Your Ref: OWPC24825
Our Ref: Y/100/19/A 05-11-2019
Please ask for:
Amber Willard

Town & Country Planning (Control of Advertisement) (England) Regulations 2007 (as amended)

Various non-illuminatged advertisements.

Land off Burndell Road Yapton

*ADDITIONAL
- SHOWHOME FLAG
900x1800MM (FLAG)
50x5993MM (FLAG POLE)

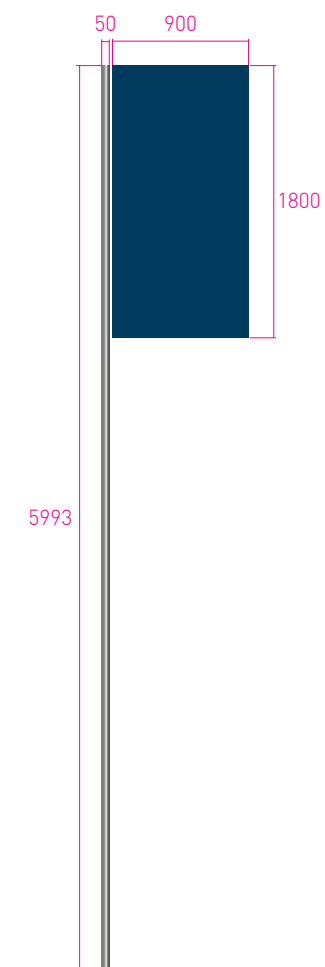
This advertising including a very large double panel, 24 smaller panels and 27 flags which were erected on 14/16 oct 2019.

The flags were particularly invasive, both visually and very noisy.

Prospective Bovis customers get a fleeting glance of the advertising, whilst existing residents are constantly subjected to the intrusion.
